WEST SUSSEX COUNTY COUNCIL CONSULTATION

TO:	Arun District Council FAO:Mr S Davis
FROM:	WSCC - Highways Authority
DATE:	23 July 2019
LOCATION:	Springfield and land to rear Hook Lane Aldingbourne PO20 3TE
SUBJECT:	AL/51/19/PL Demolition of the existing dwelling & erection of 3 No 2-bed, 3 No 3-bed & 4 No 4-bed dwellings, access, landscaping & associated works.
DATE OF SITE VISIT:	N/A
RECOMMENDATION:	No Objection
S106 CONTRIBUTION TOTAL:	N/A

title	VISIBILITY SPLAYS AT ACCESS
-------	-----------------------------

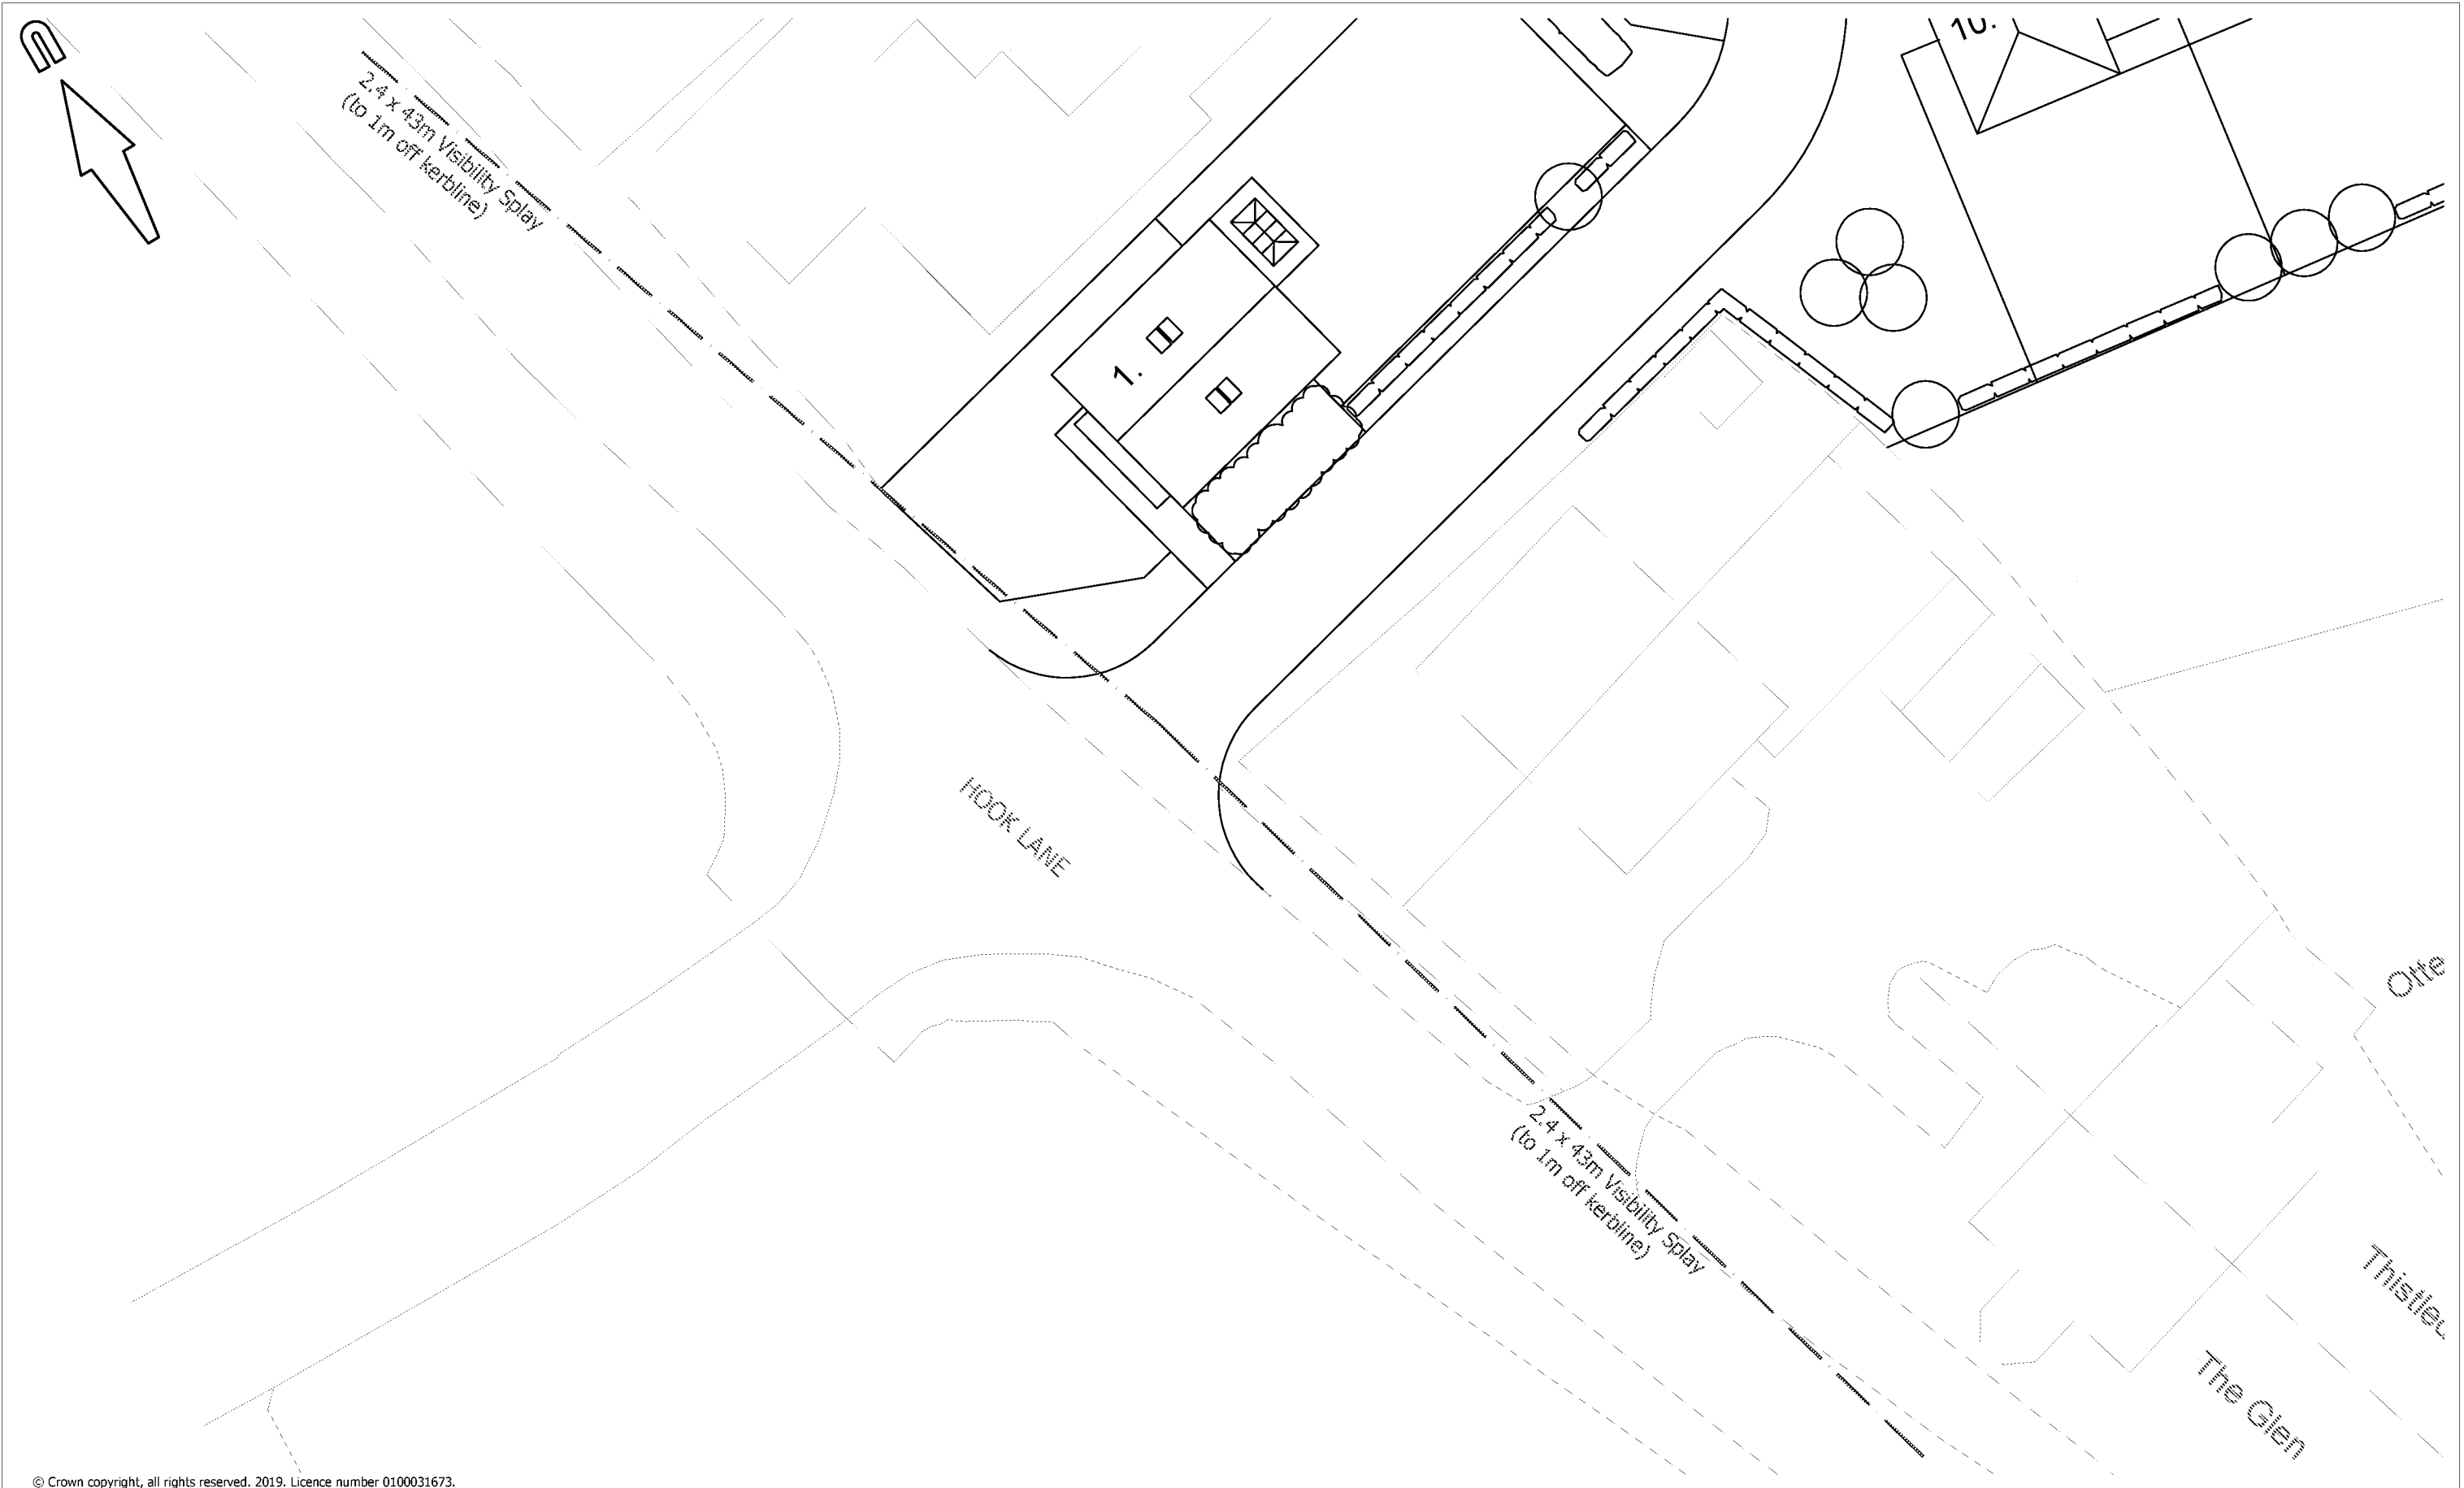
No part of the development shall be first occupied until visibility splays of 2.4 metres by 43 metres have been provided at the proposed site vehicular access onto Hook Lane in accordance with the approved planning drawings. Once provided the splays shall thereafter be maintained and kept free of all obstructions over a height of 0.6 metre above adjoining carriageway level or as otherwise agreed.
